Re: Objection to MP08\_0244 MOD 1 Modification Request for Mixed Used Development at 23-37 Lindfield Avenue and 11 Havilah Lane, Lindfield

As a resident of Lindfield, I/we wish to lodge an objection against the proposed Modification of the subject development based on the following grounds:

1 HAVILAH LA ELEVATION
2001 SCALE1 : 250

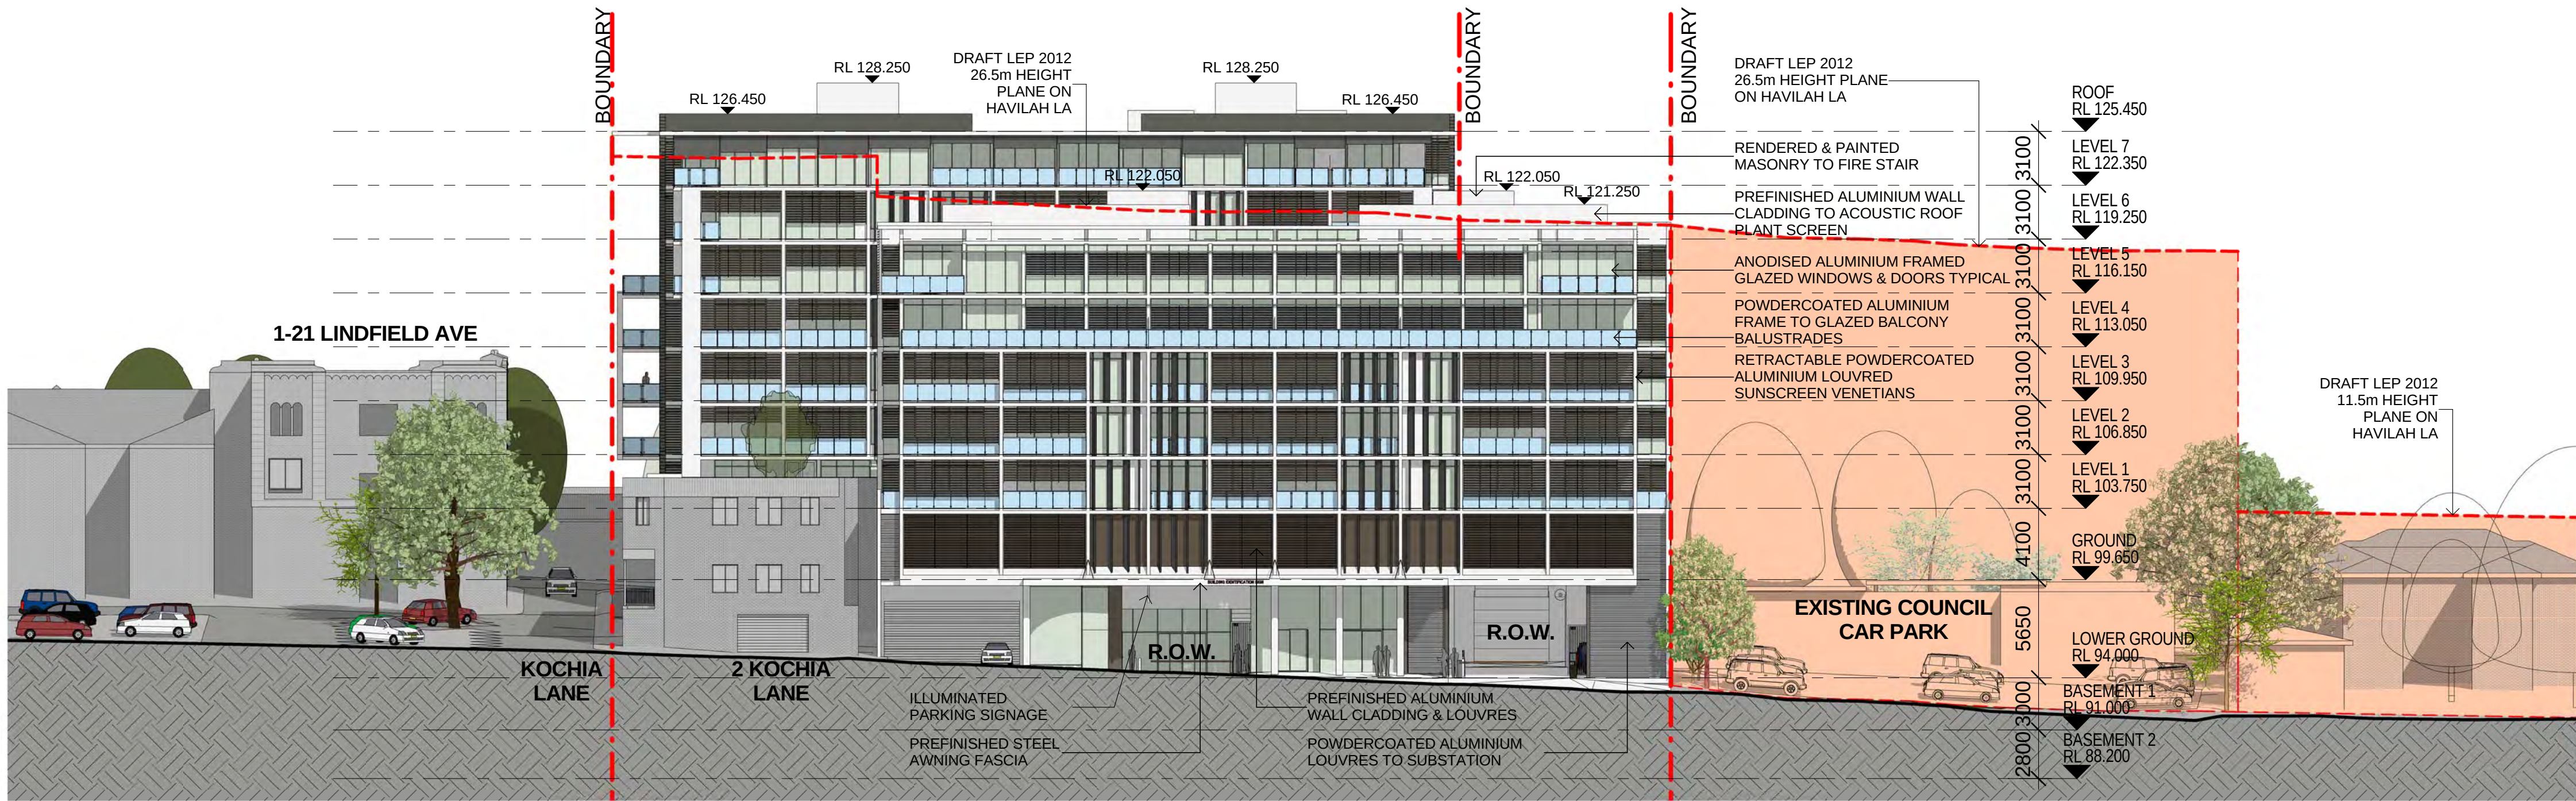
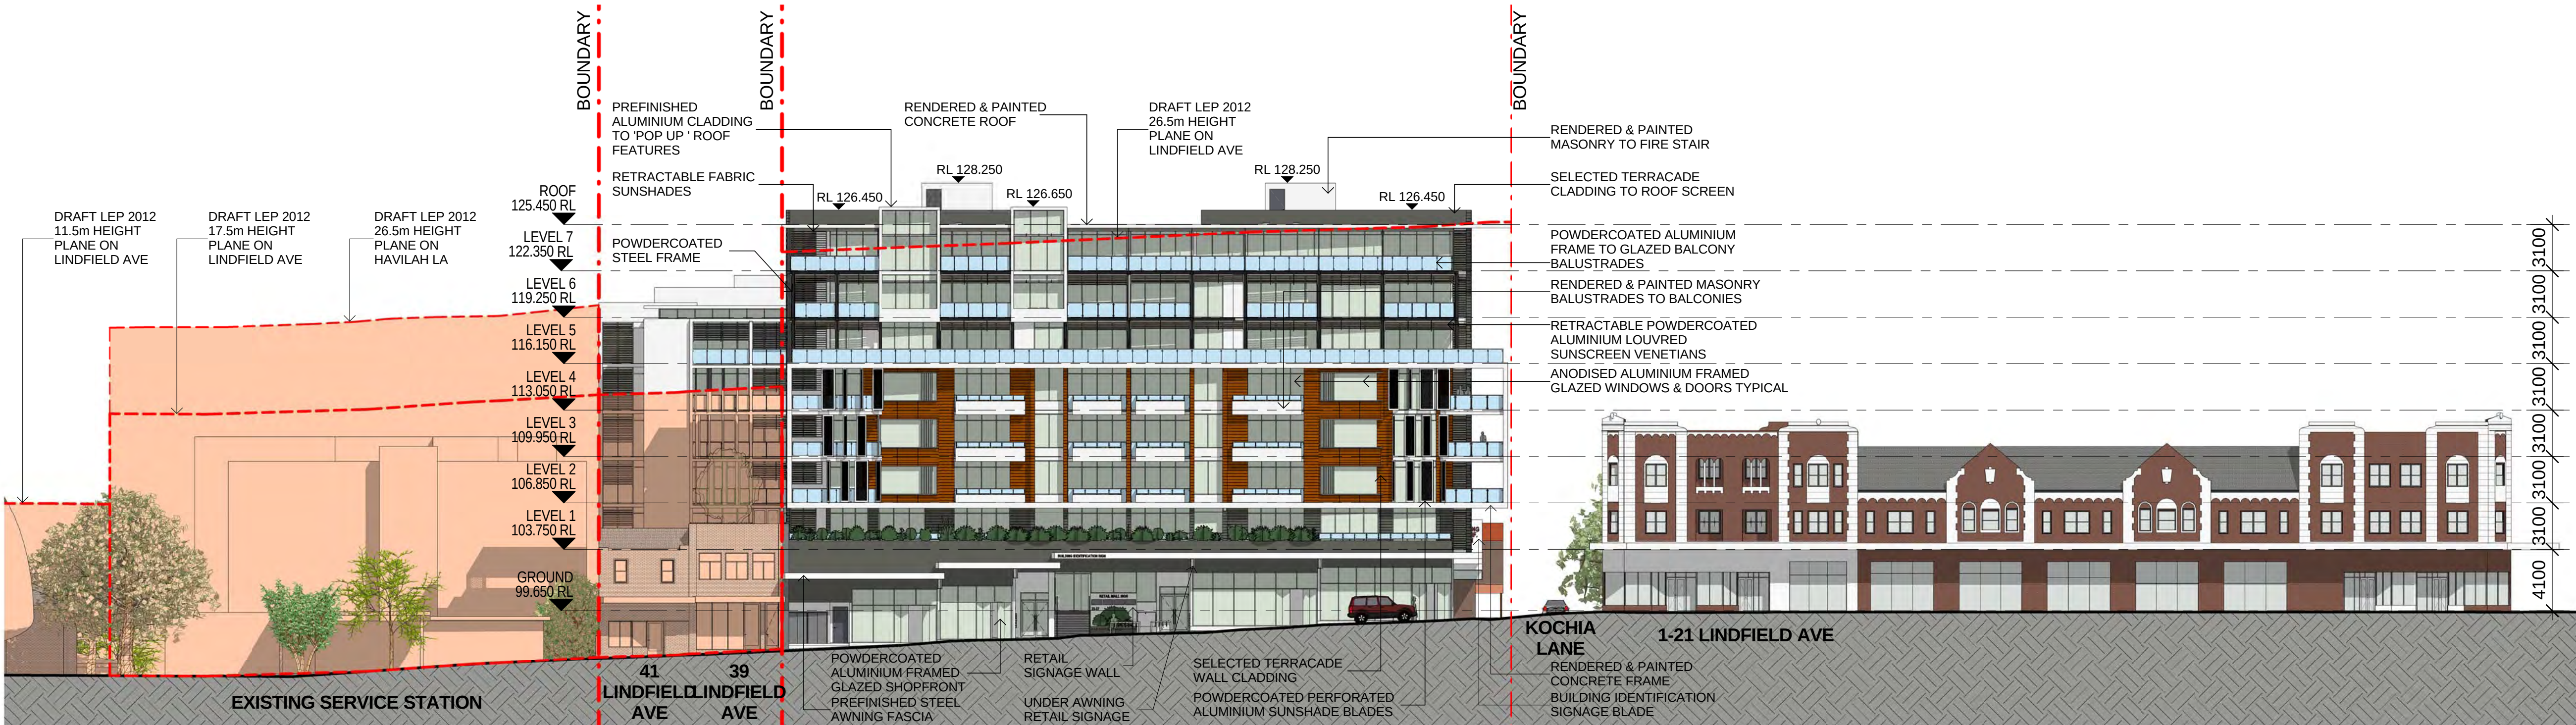
- The increase of an additional storey to both buildings: 8 storeys on Lindfield Avenue and 7 storeys on Havilah Lane creates excessive height and bulk and is out of character with the surrounding buildings, including the heritage listed adjacent building on Lindfield Avenue

- The additional storey (combined with less set back than the approved design) on Havilah Lane now creates privacy concerns for over 40 apartments in the adjacent 8 Havilah Lane, 8 Kochia Lane and 2-8 Milray Street residences
